Supplementary submission by an observer in response to the applicant's Response to Observations

Application: Knockshanvo Wind Farm, Co. Clare (nine wind turbines, 110kV substation and ancillary development)

Case reference: ABP-320705-24

Responding to: Knockshanvo Wind Farm Response to Observations (Rev 01, Final, 17 April 2026), prepared by MKO

Figure 1 Cumulative Predicted Noise Contours

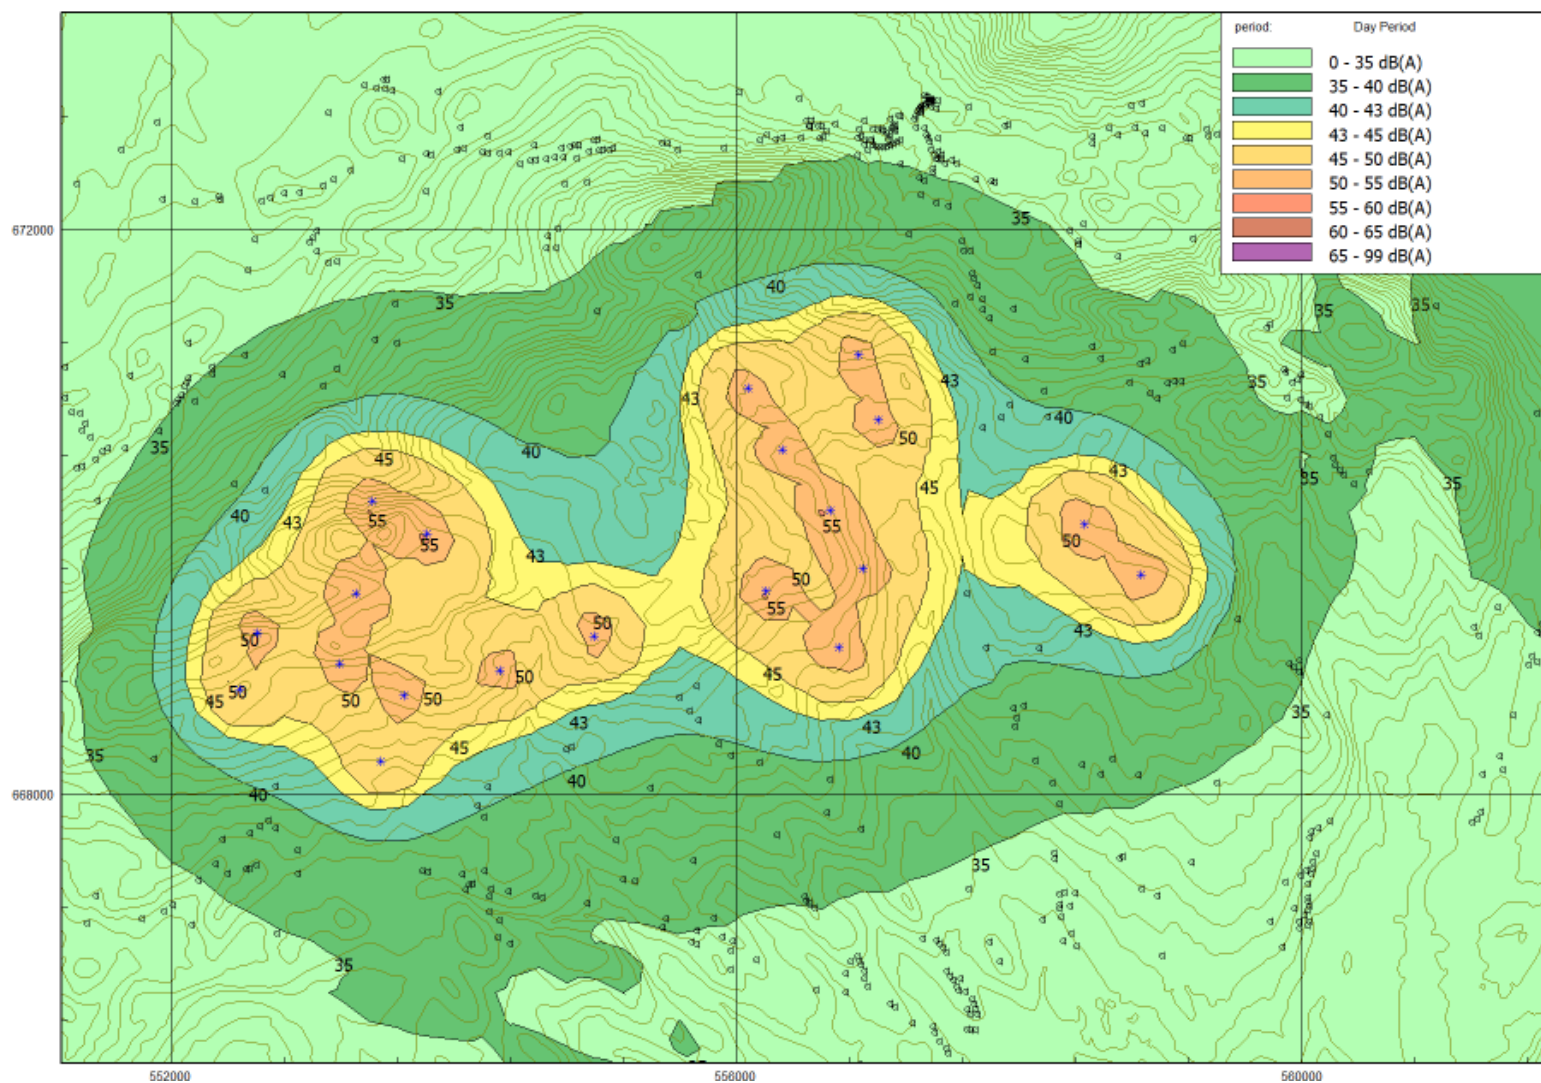
The acoustic response answers a narrower question. It states that the criteria applied to the centre treat the location *“as permanent residence... the same as all other locations”*, and reports a worst case cumulative predicted level of 38.5 dB LA90 as being within that criterion. That confirms the flaw rather than resolving it. A limit calibrated to protect ordinary residential amenity, principally sleep and normal domestic activity, is not evidence that a facility whose purpose is contemplative silence will remain fit for that purpose. Passing a house limit and preserving a retreat are different findings, and only the first has been made.

- **Disclosure and use of the retreat baseline.** That the measured baseline noise level recorded at the retreat (Location A in the assessment) be placed on the file, and that the operational noise limit at the centre be set by reference to that measured baseline plus an appropriate margin, rather than the standard dwelling limit.
